20 October 2023

**RE: 74-76 BEACONSFIELD ROAD, MOSS VALE, NSW 2577
SSD-9409987
CONSTRUCTION AND OPERATION OF A PLASTICS RECYCLING
FACILITY WITH THE CAPACITY TO PROCESS UP TO 120,000 TONNES
OF PLASTIC WASTE PER ANNUM INTO USABLE PRODUCTS**

GAT & Associates have been engaged by the owners of the adjacent western property, No. 64, 86 & 100 Brookdale Road, to prepare a submission with respect to their concerns surrounding the proposed development.

A stormwater collection and quality treatment train is proposed as shown on Figure 3.1, including the following:

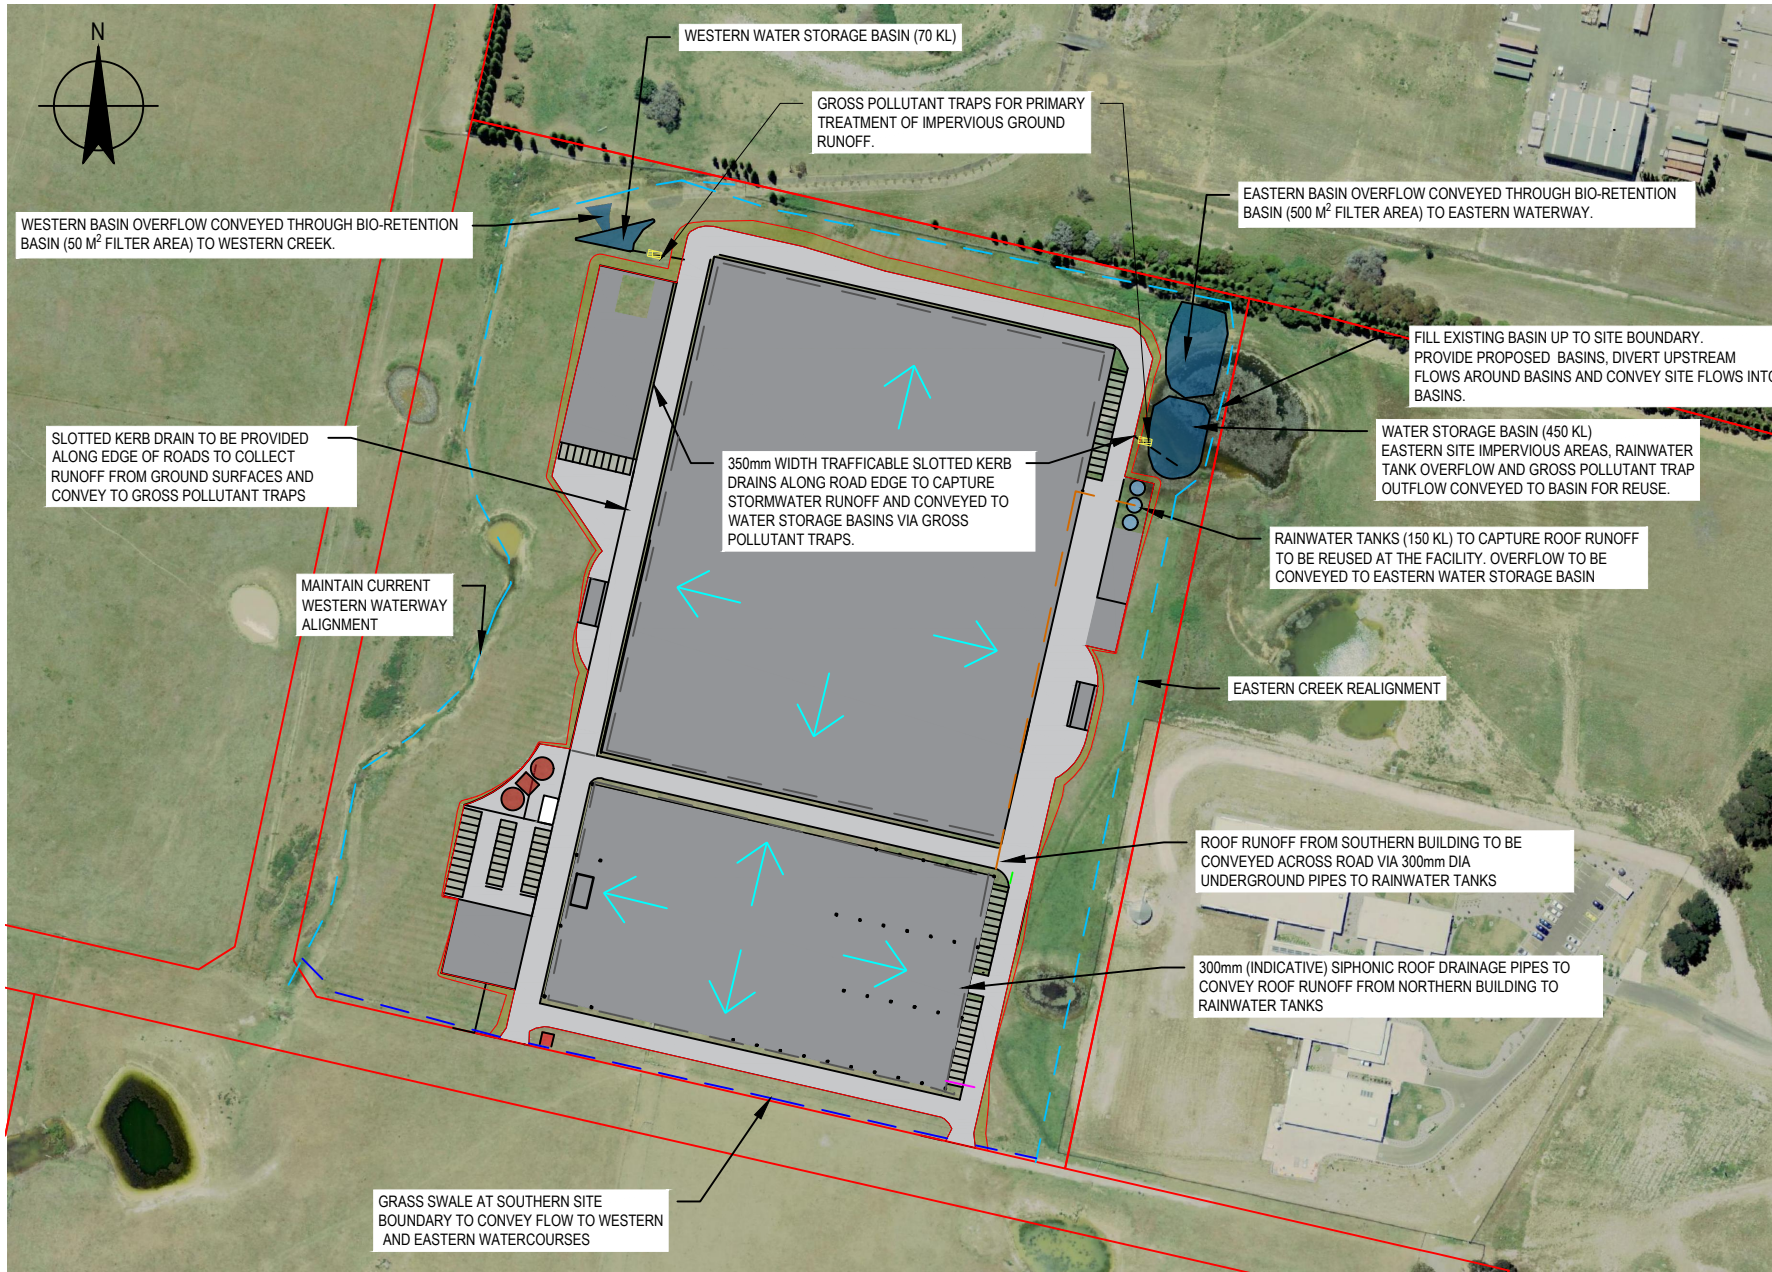
The submitted documentation indicates that the stormwater bio-retention basins have been relocated based on updated flood modelling results. However, the new locations for the bio-retention basins are still in proximity to flood prone land and waterways which flow directly to the Wingecarribee River, a major tributary that forms part of the Sydney drinking water catchment. In the previous objection letter prepared, the following concern was raised;

As previously raised, there is concern that in an event of an extreme flood, increased stormwater runoff may bypass pollution control measures and subsequently flow into the Sydney drinking water catchment. This concern does not appear to have been addressed in the amended documentation with the following comment noted within Submissions Report in response to WaterNSW comments:

Details on stormwater drainage and management plans should be provided prior to determination especially considering the site is within the Sydney water drinking catchment. This is to ensure that the public and consent authority are certain that the proposed stormwater and wastewater management systems will not result in any contamination to the Sydney drinking water catchment.
